**WELWYN HATFIELD COUNCIL – DEVELOPMENT CONTROL**  
**DELEGATED REPORT**

<b>APPLICATION No:</b>	<b>S6/2008/1157/LB</b>
------------------------	------------------------

**DESCRIPTION OF PROPOSAL:**

PLAN AS PROPOSED.

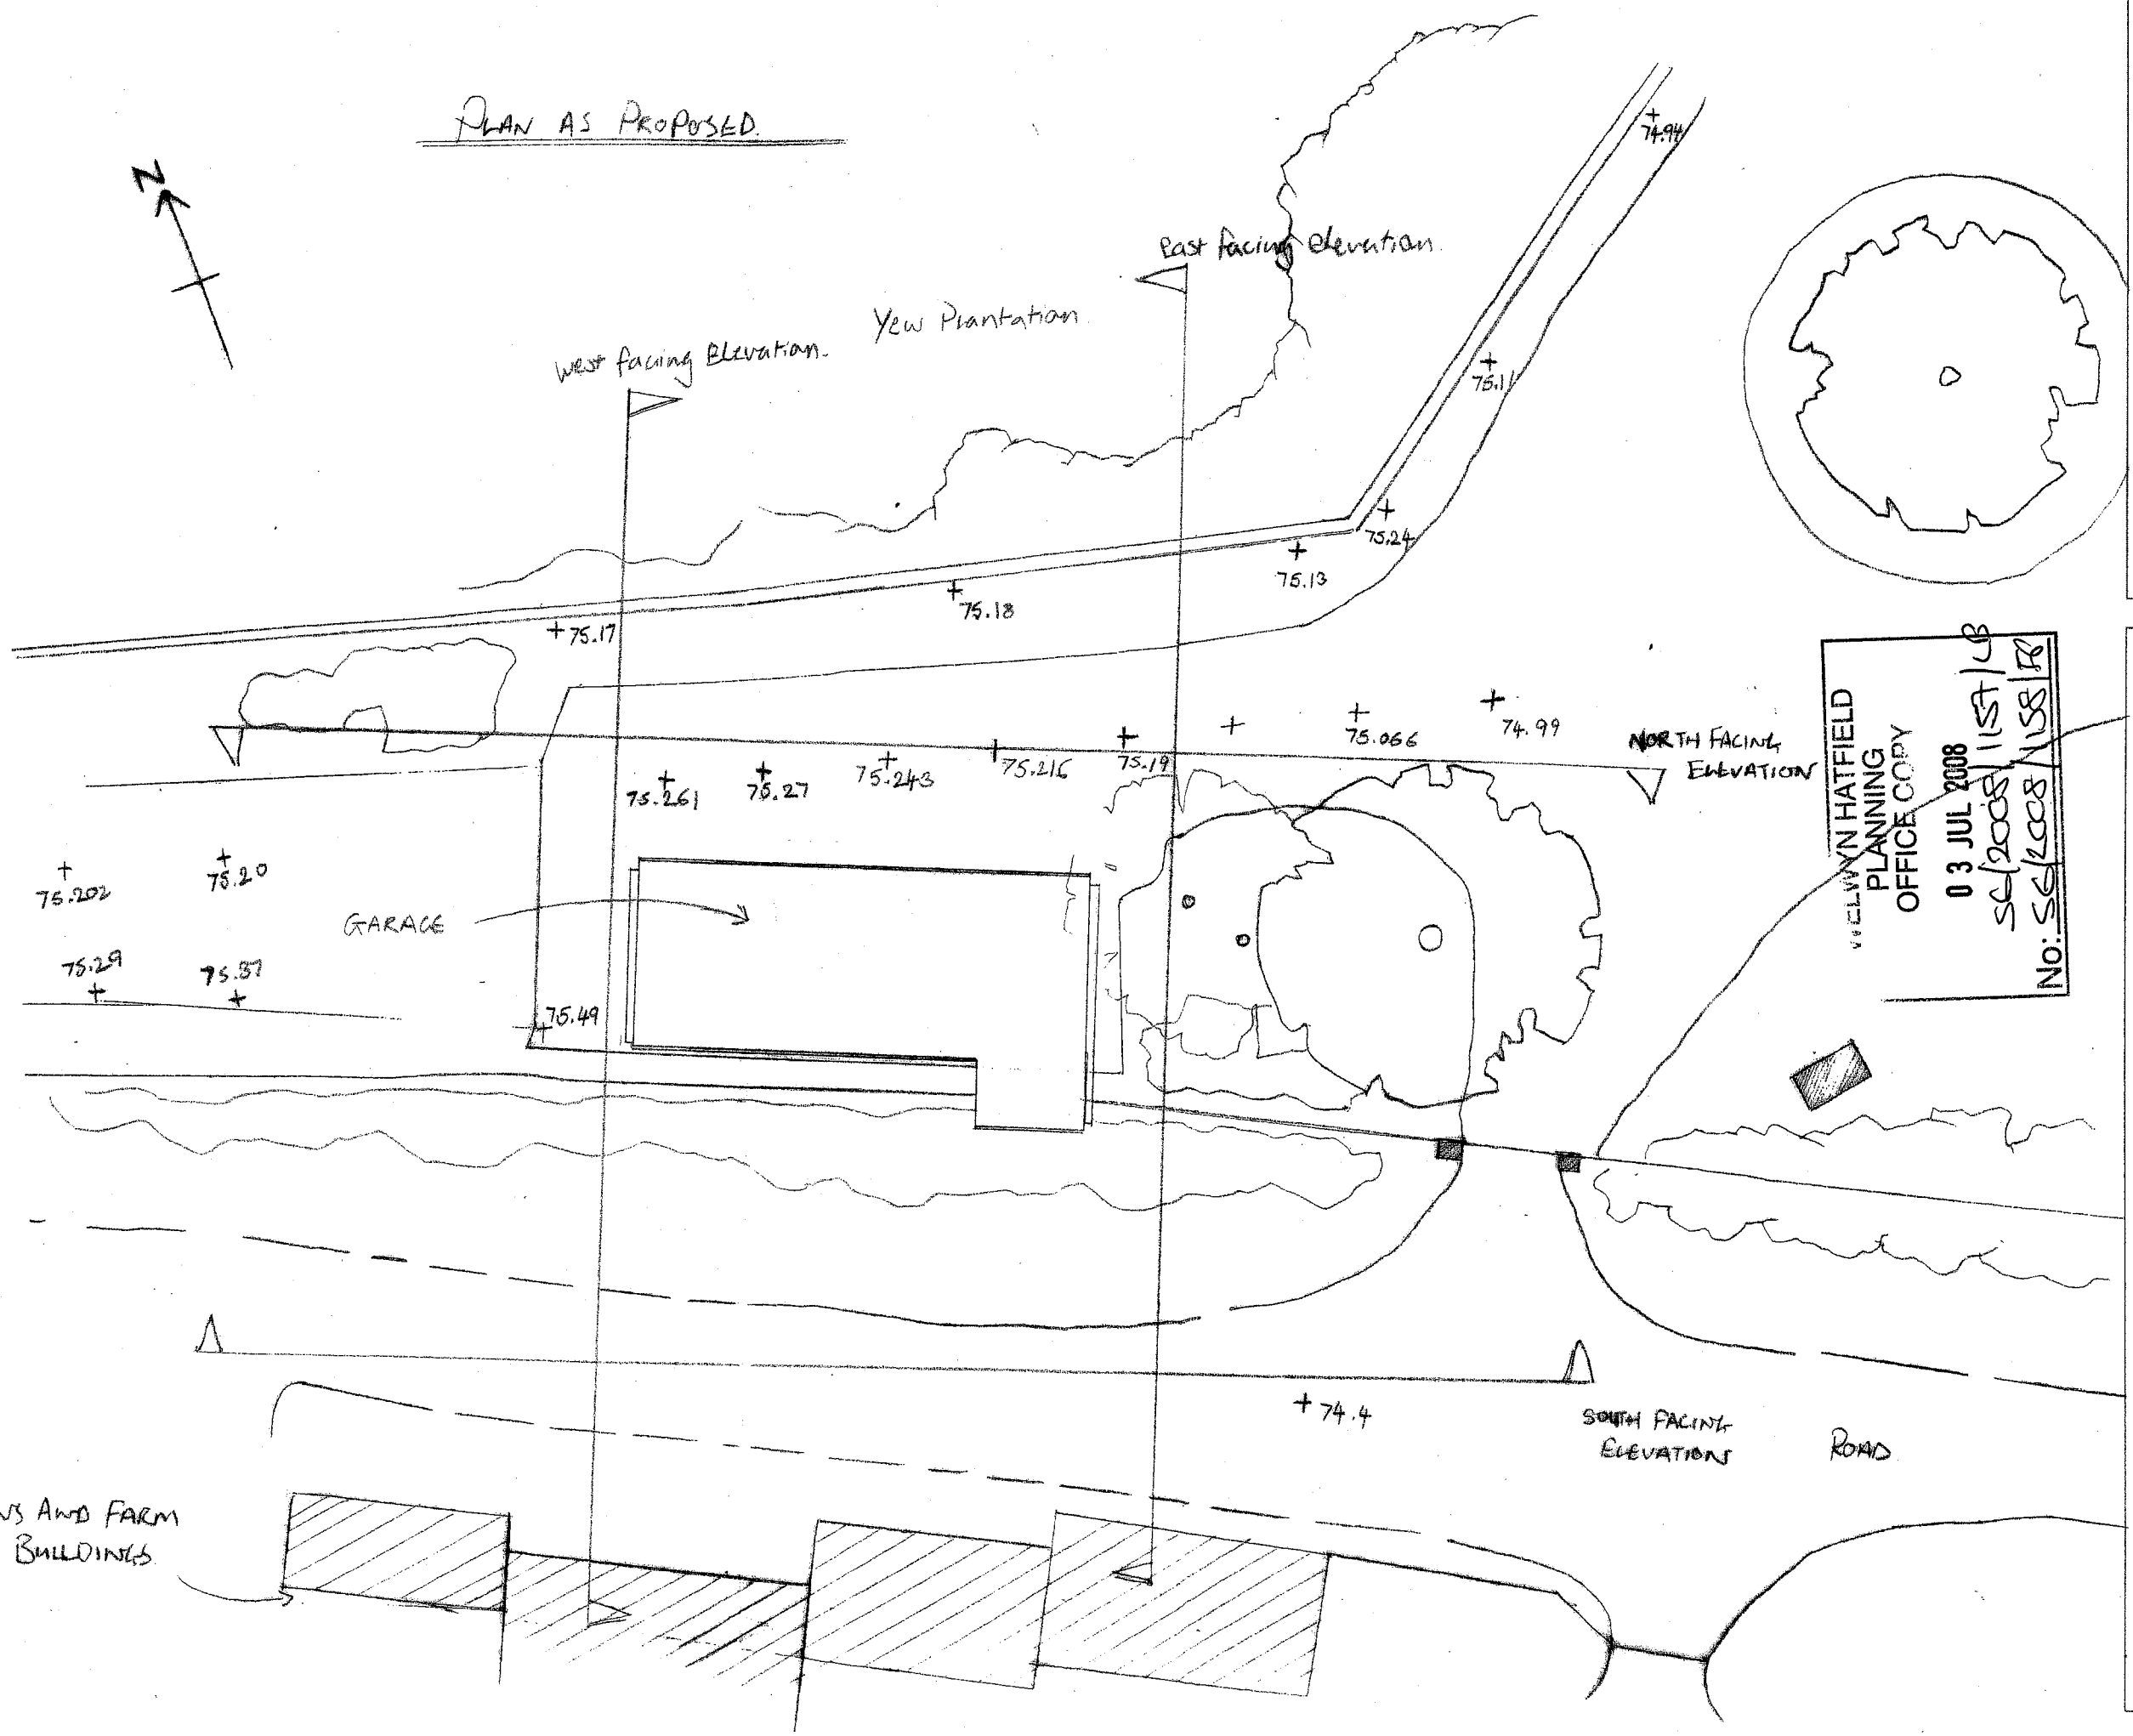
The proposed development would involve the erection of a detached garage with accommodation within the roofspace. This addition would measure 14.5m in width by 6.2m in depth with a ridged roof to a maximum height of 7.5m. The northern and southern planes of the roof would have pitched roofed dormer windows measuring 1.5m in width by 3.0m in height. The flank elevations of this building would have an ornate design with circular windows. The agent has stated that the proposed side elevations are based on the lost curvilinear Dutch gables, which existed on the house before 1790. The garage has been illustrated to have a weather vane which would have a height of 8.6m from the adjacent ground level.

The proposed development would create a separate unit with residential accommodation above. Due to the design of the proposal it would have glazing at roof level, which would be noticeable from the surrounding area. The proposal would be viewed from Wilkins Green Lane and would be seen when approaching the main building. The proposed garage building would be within the same street scene and clearly be on the same plot as the main building. The proposal would have a maximum height of approximately 6.8m, which would mean that the building is viewed clearly above the adjacent boundary. Due to the proposed ornate design of the flank elevations and overall prominence of the building, it would have an adverse impact upon the setting of the main Listed Building. It has been acknowledged that the design has been based on a previous feature of the main building. However, this addition would not reflect the existing Listed Building and would not enhance its setting.

Garage 6103/2/10

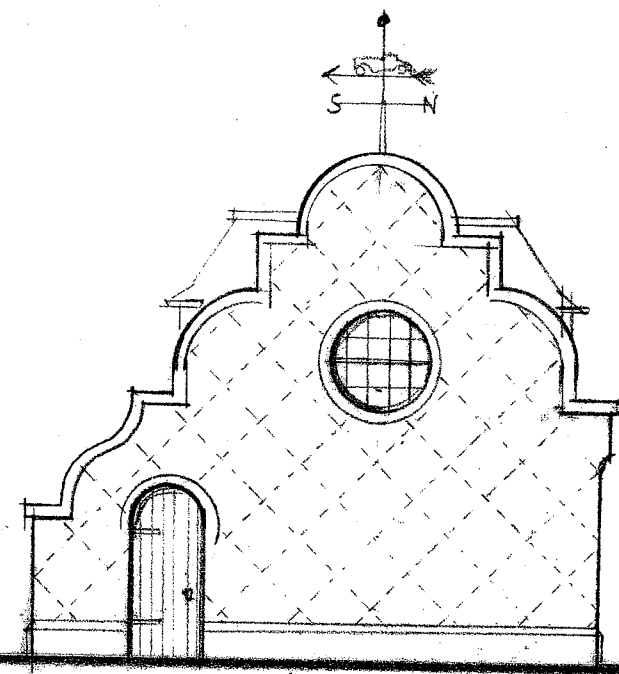
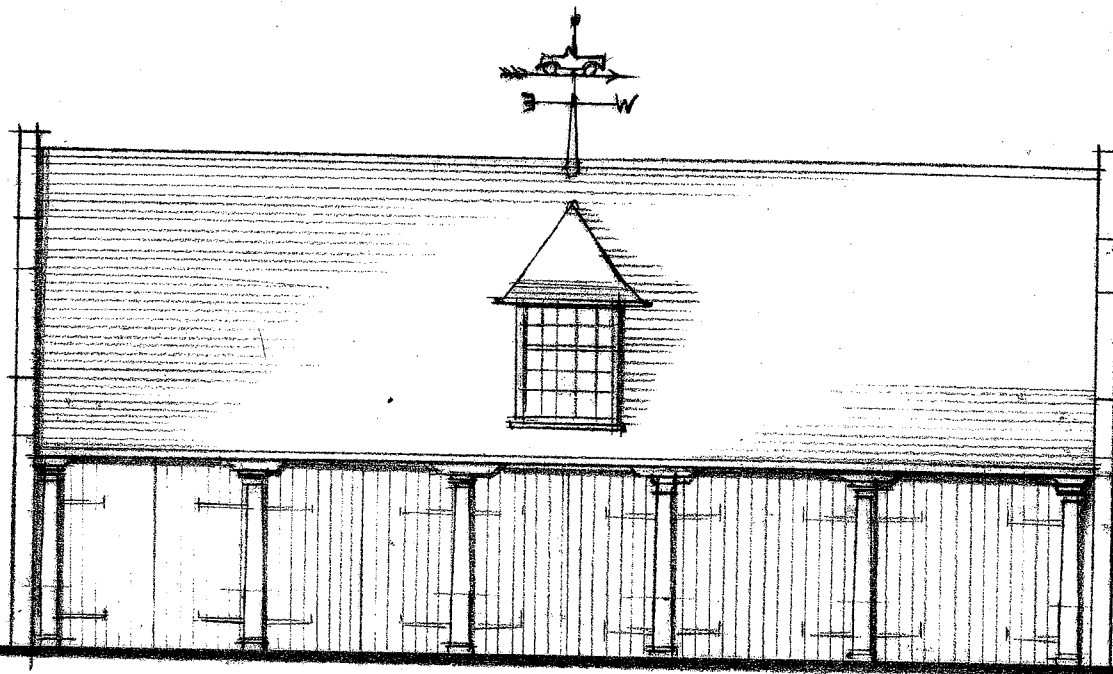
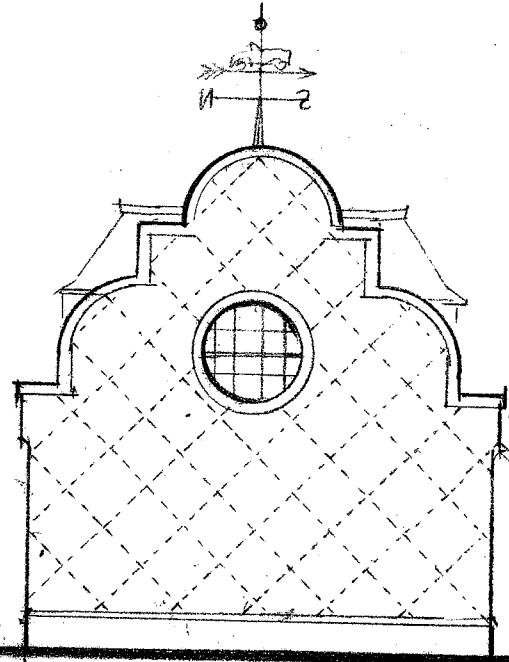
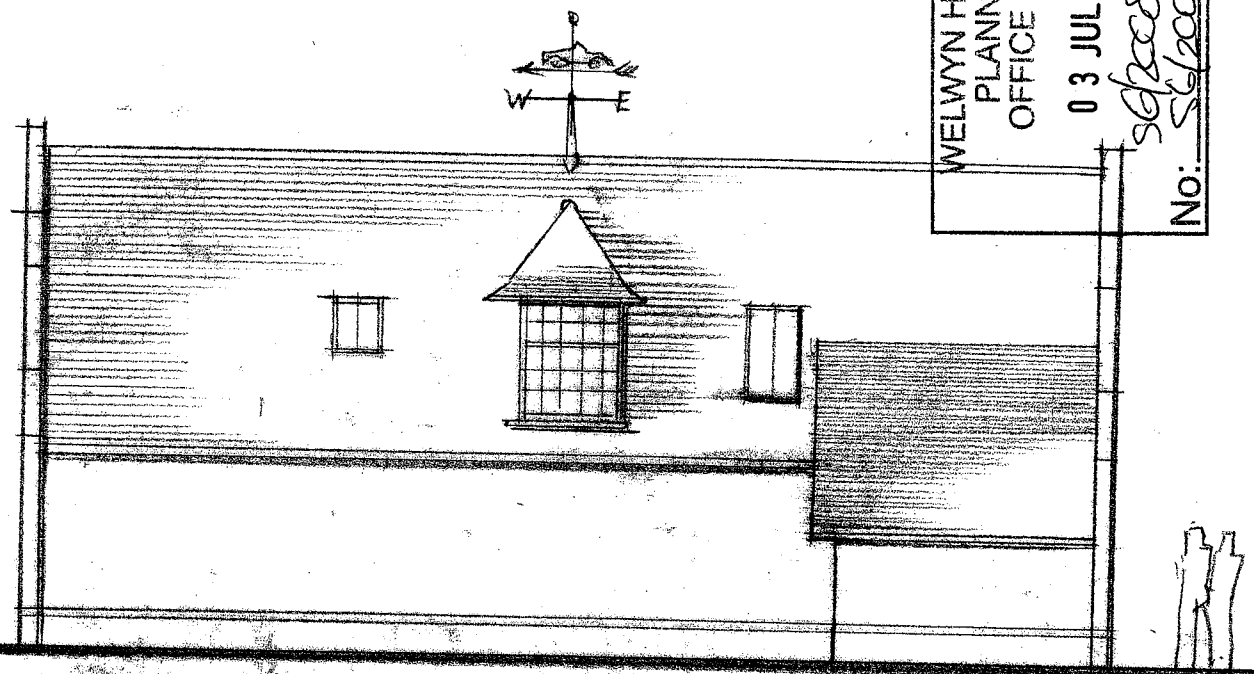
When considered cumulatively with the recently approved entrance gates and pillars the, the appearance of the proposal would be exacerbated. The proposed garage building would have an inappropriate design that would detract from the appearance of the Listed Building. The proposed building would also be excessive in terms of its mass, bulk and prominence. When considering with the proposed garages and proximity to the adjacent highway, it would have an adverse impact upon the character, appearance and setting of the Listed Building. The proposed development would therefore be contrary to PPG15.

The proposed detached garage would form a highly prominent structure within the immediate setting of the main house. The garage would detract from the appearance of the Listed Building and have a detrimental impact upon the existing character and appearance of the locality. There is insufficient evidence to justify such a significant change and harmful impact to their overall appearance. The proposal therefore does not comply with the requirements of PPG15 (Planning and the Historic Environment).
